Engineers Comments Regarding Surface Water Drainage

Application Reference:	LU/157/26/PL	Reviewer Reference:	ADC/EXT5/AF
Planning Officer:	Hebe Smith	Date of Review:	07/08/2026
Site Name:	Wick Football Club Crabtree Park Coomes Way Littlehampton BN17 7LS		
Application Description:	Change of surface from grass to artificial turf and erection of new 2.5m acoustic fencing. This application is in CIL Zone 2 (zero rated) as all other development.		
Assessment Number:	1

Appendix G
Proposed Drainage Strategy
JPP Consulting drawing no. 31285-FRA03

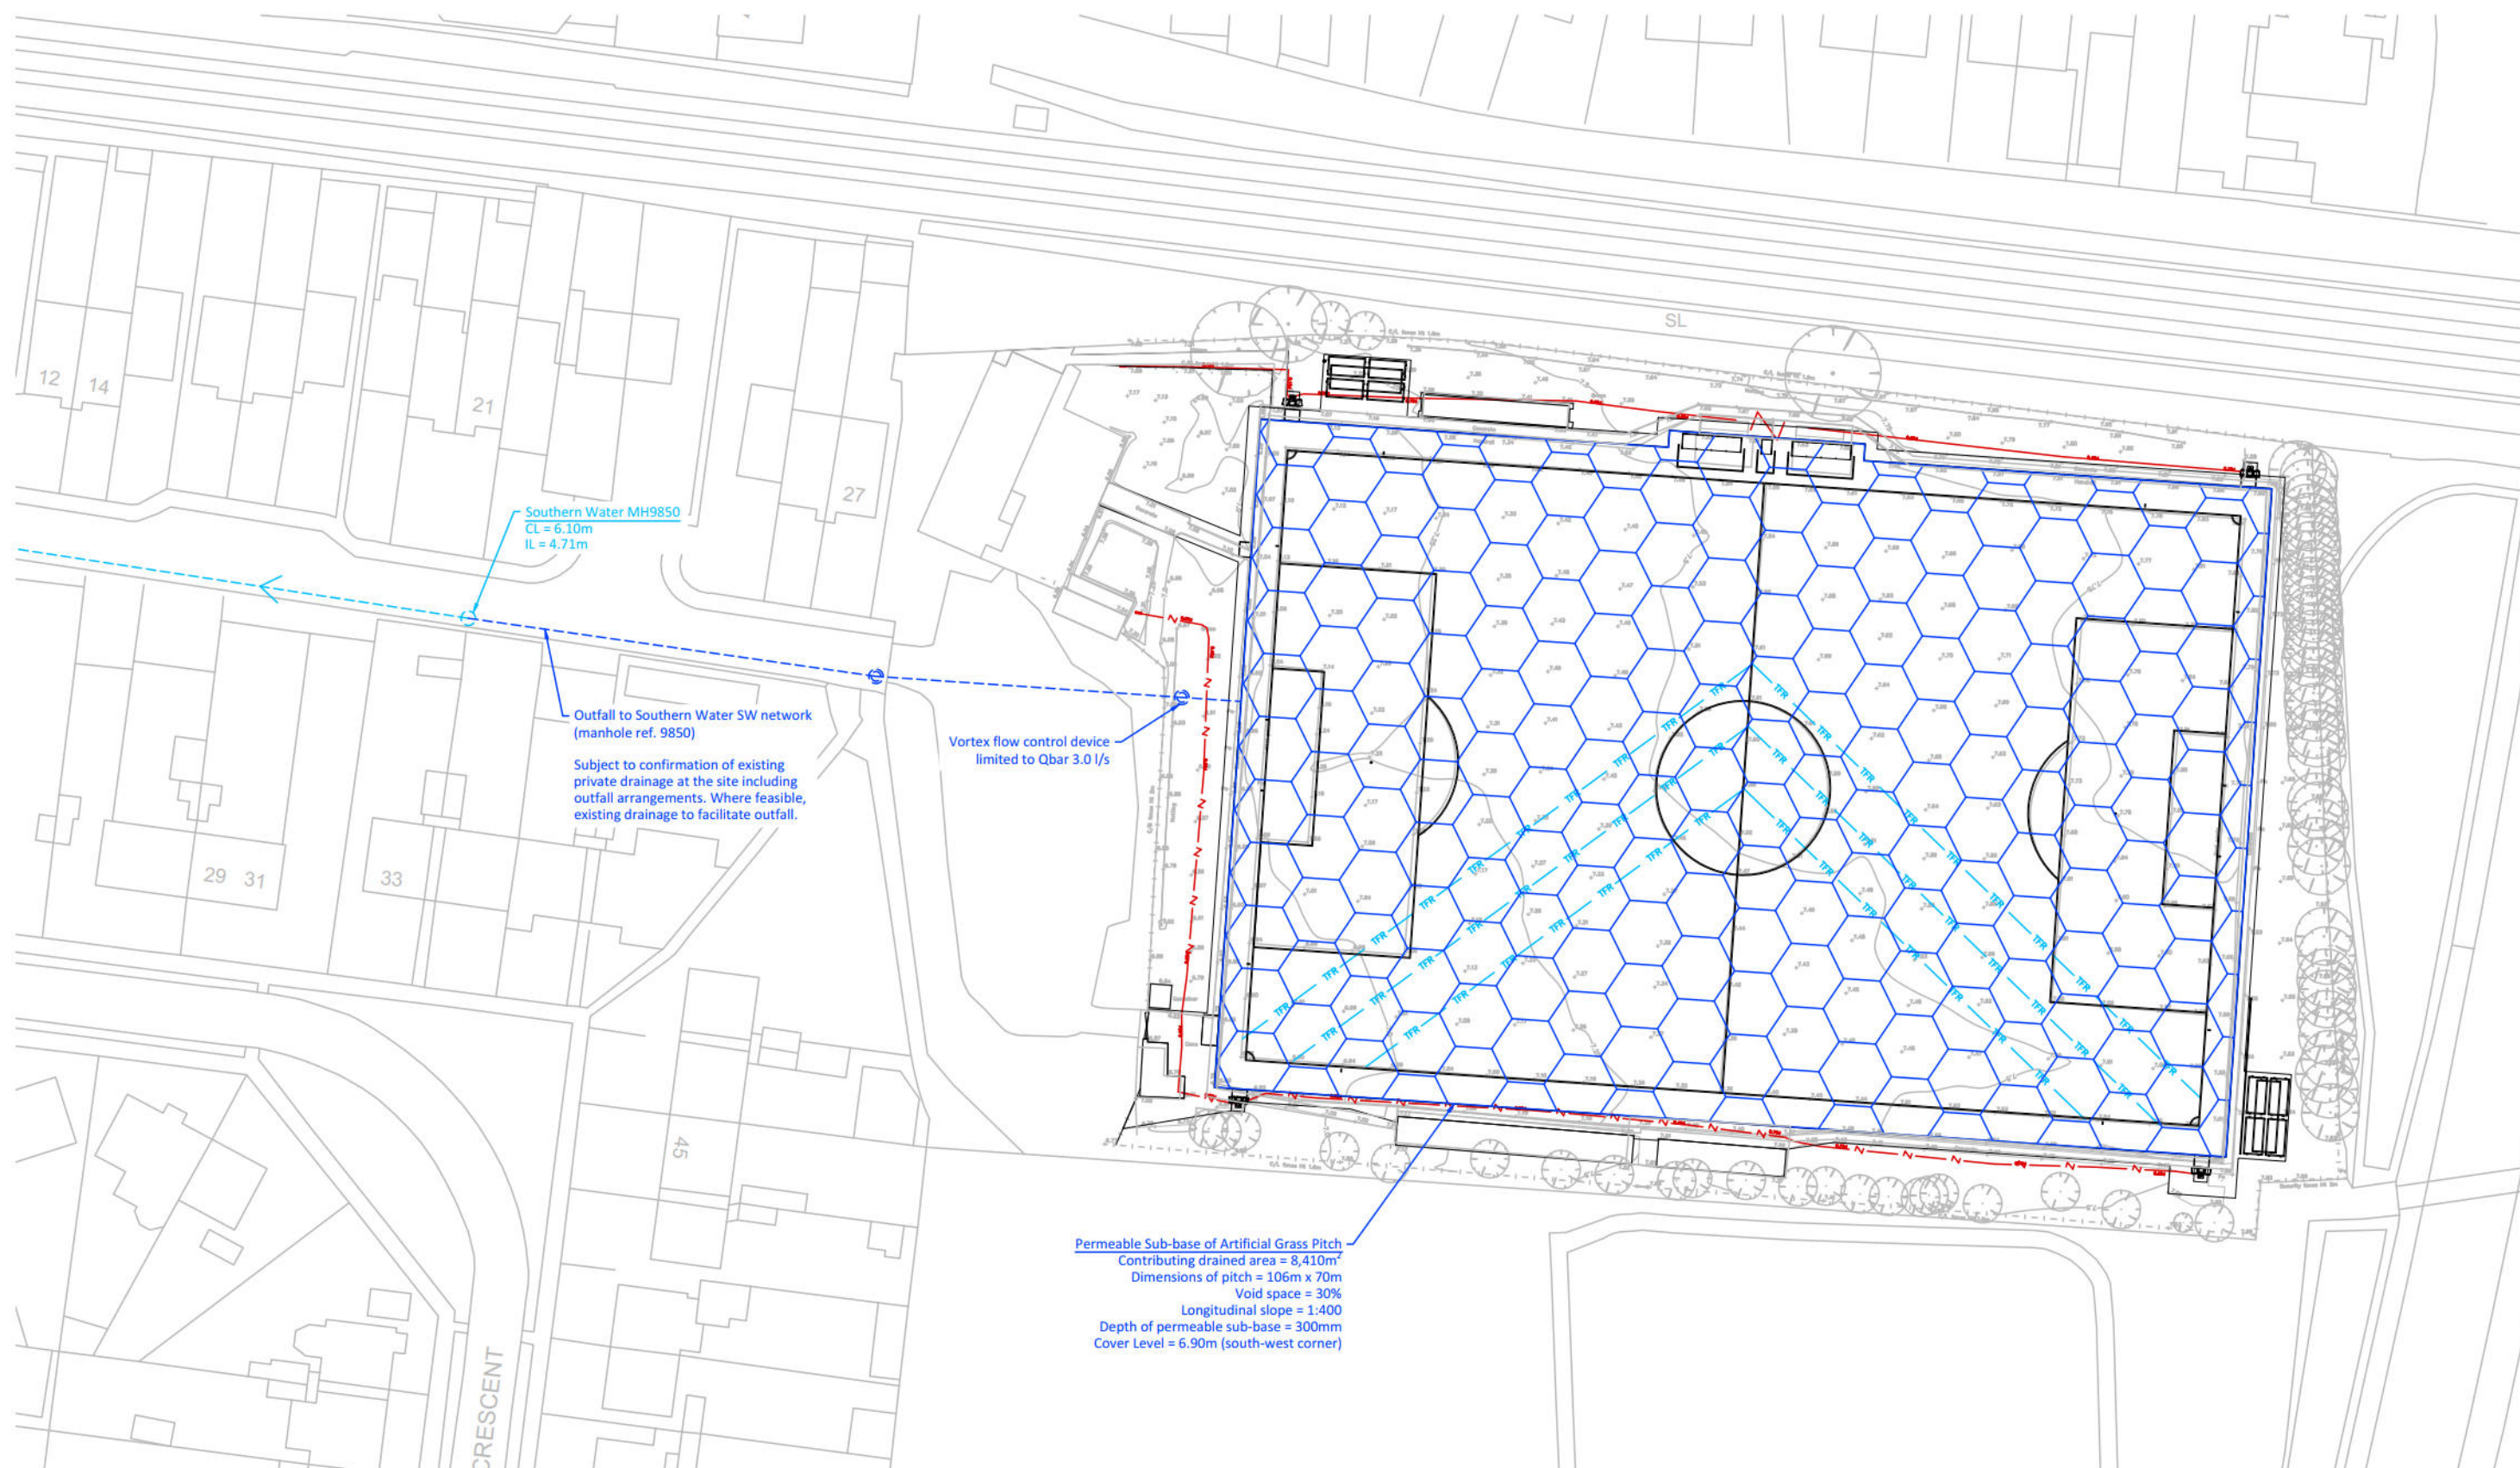
- 1.1. There is likely to be an irrigation demand at the site and it would be applicable to consider reuse of rainwater for this development, this may be achieved by incorporating rainwater harvesting upstream of the point of discharge for water drained from the pitch.
- 1.2. The drainage strategy shows pitch drainage discharged to a soakaway, however, no groundwater monitoring or infiltration testing has been provided to demonstrate the feasibility of the infiltration solution.
- 1.3. The drainage strategy does not appear to include the alterations to hard paving and other development works to the west of the pitch.
- 1.4. Further information is required to confirm the design is in accordance with the requirements of the NSfS (Standard 1). The current submission does not demonstrate compliance with the standard, therefore, we **Object** to the development.

- 2.1. The design currently provides interception drainage through infiltration. However, the infiltration solution has not been evidenced and may not be feasible and the drainage strategy does not appear to include all aspects of the development.
- 2.2. Further information to demonstrate interception drainage is provided by the design is required.
